Demolition & erection of 70 bed care home within Use Class C2 (replacing building 4 approved by A/27/16/PL), access, parking, landscaping and other associated works
Broadlees Dappers Lane Angmering

Thank you for your internet representation made on 27th September 2018 which has been recorded as '**an objection**' with the comments as follows:

Appendix E – Proposed Pedestrian Infrastructure

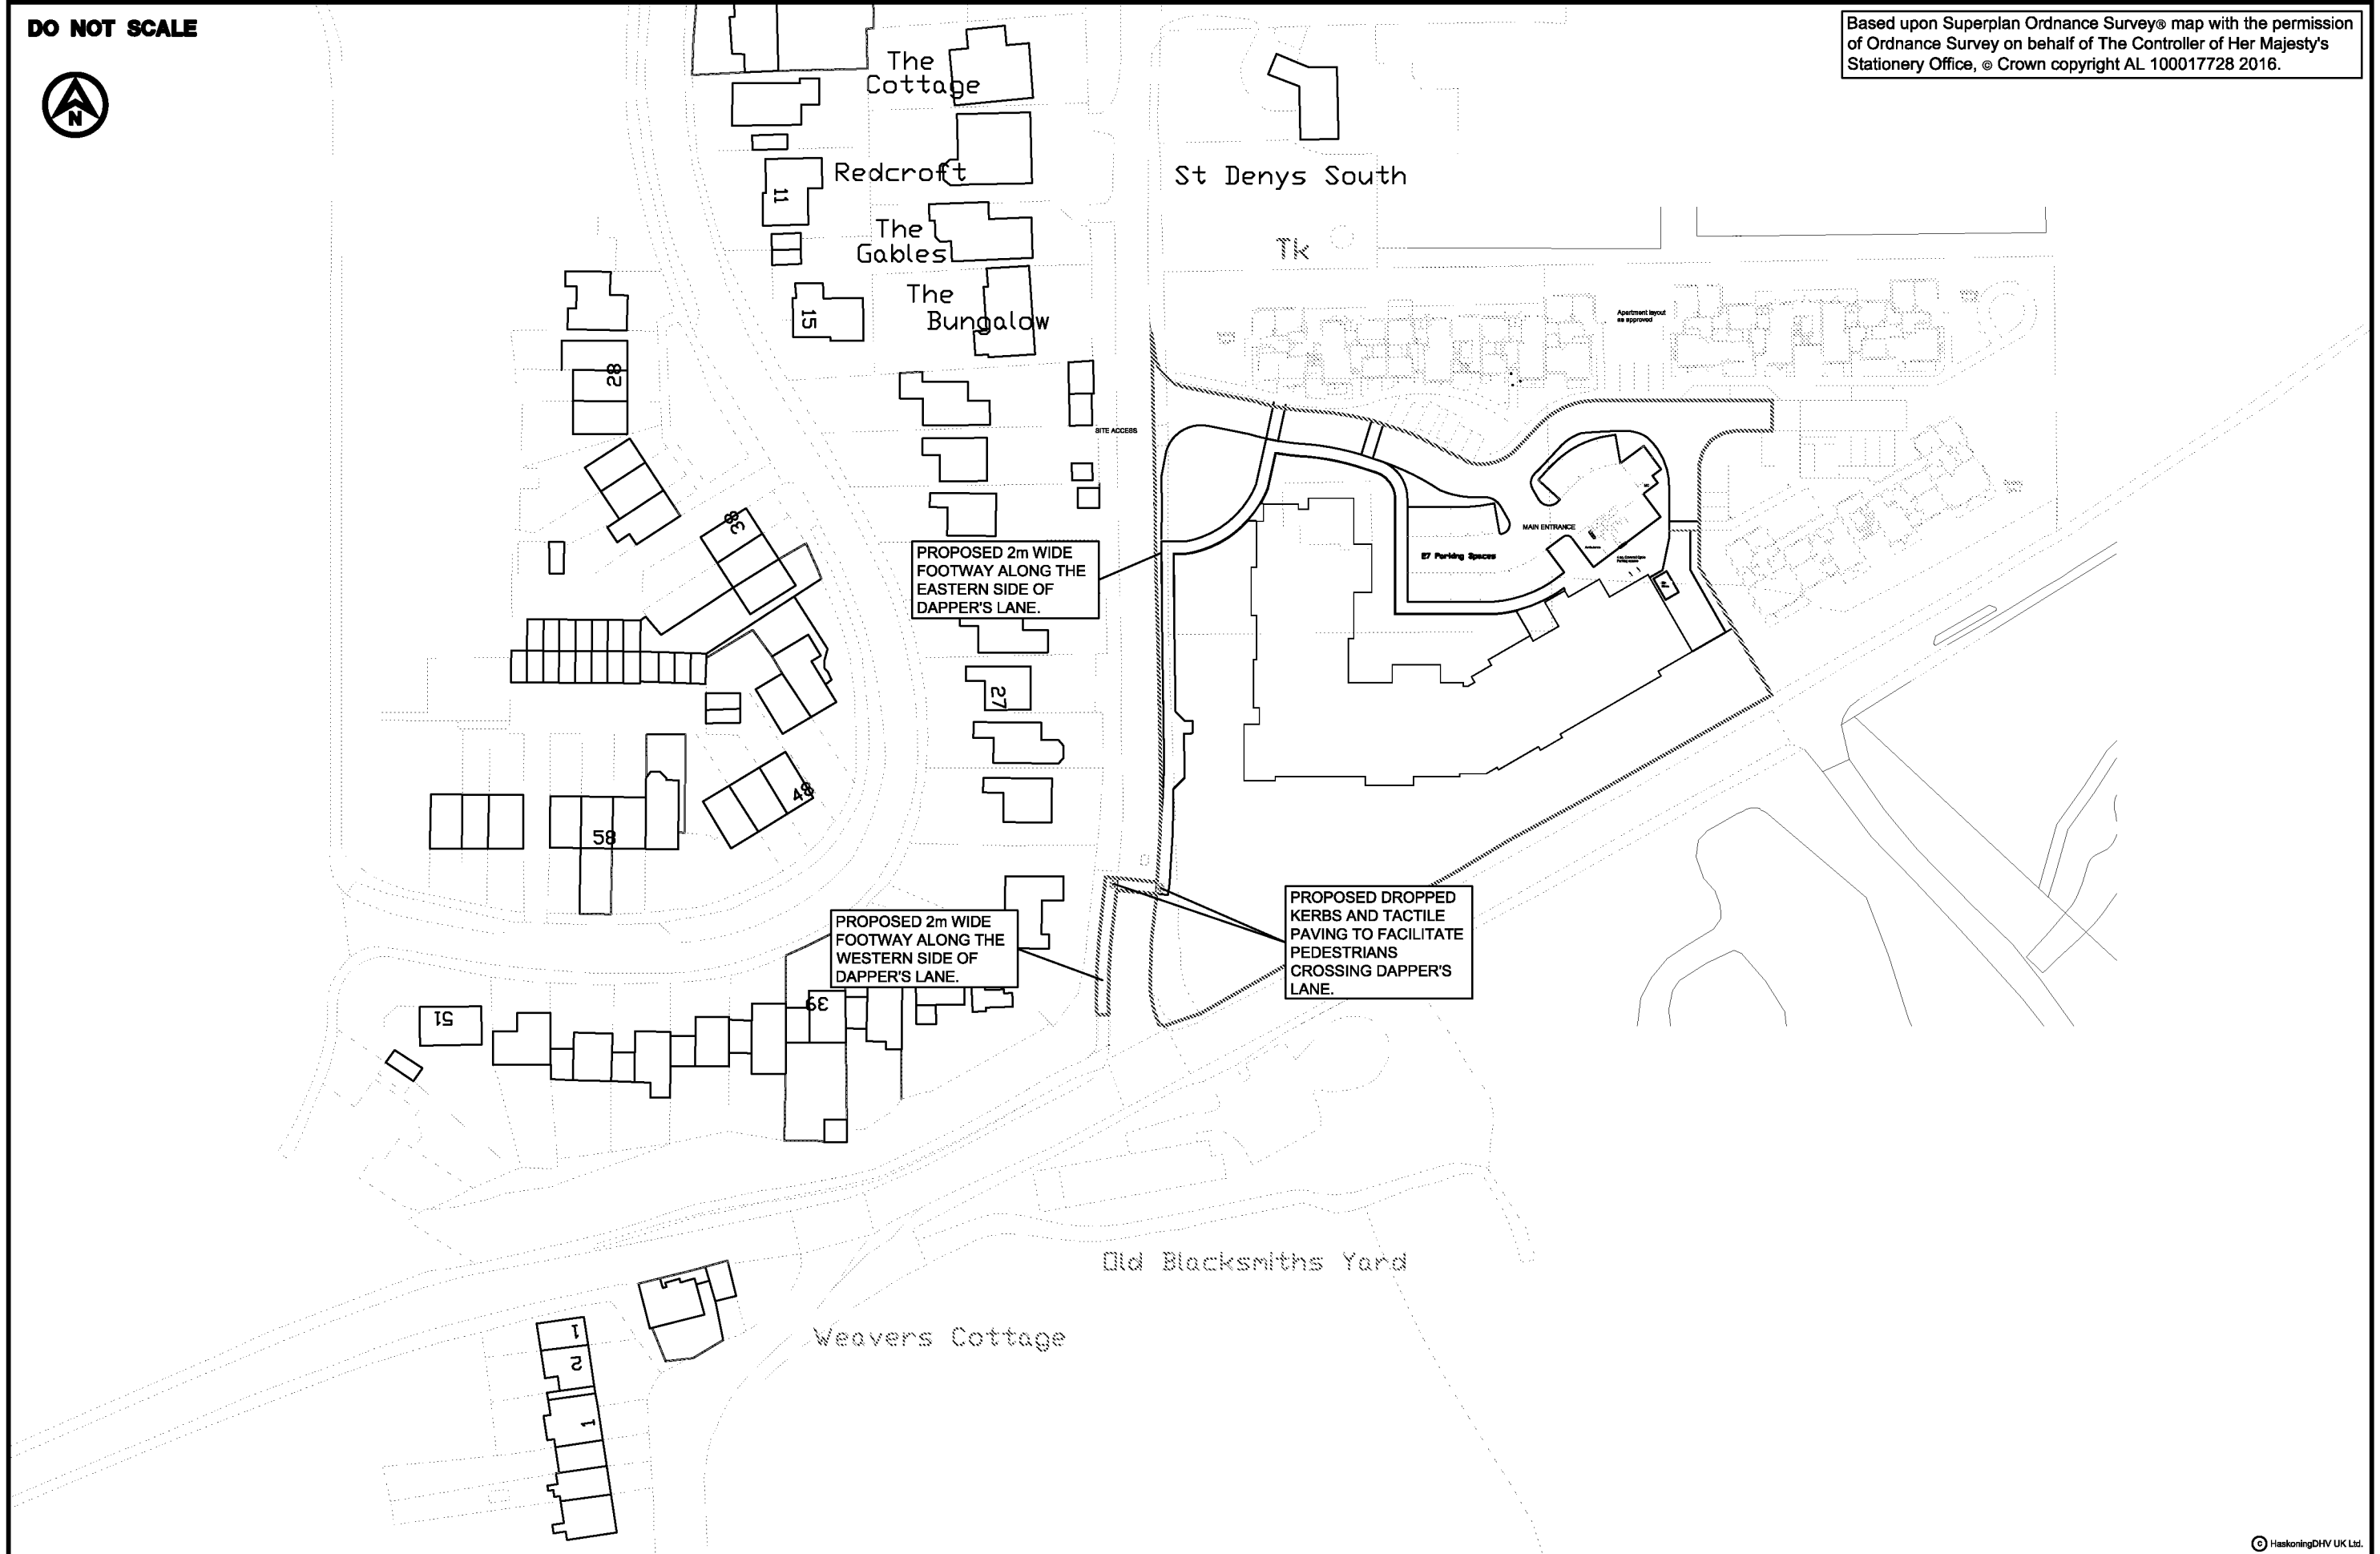
The planned foot crossing across Dappers Lane seems too near to the Water Lane junction and this may put pedestrians at risk, especially if there are parked cars there.

There is no footpath planned to run north from the development up Dappers Lane to the Merryfield Crescent junction where the bus stop is. This will lead to pedestrians using the bus service who are likely to be elderly being at risk from walking in the road to the care home.
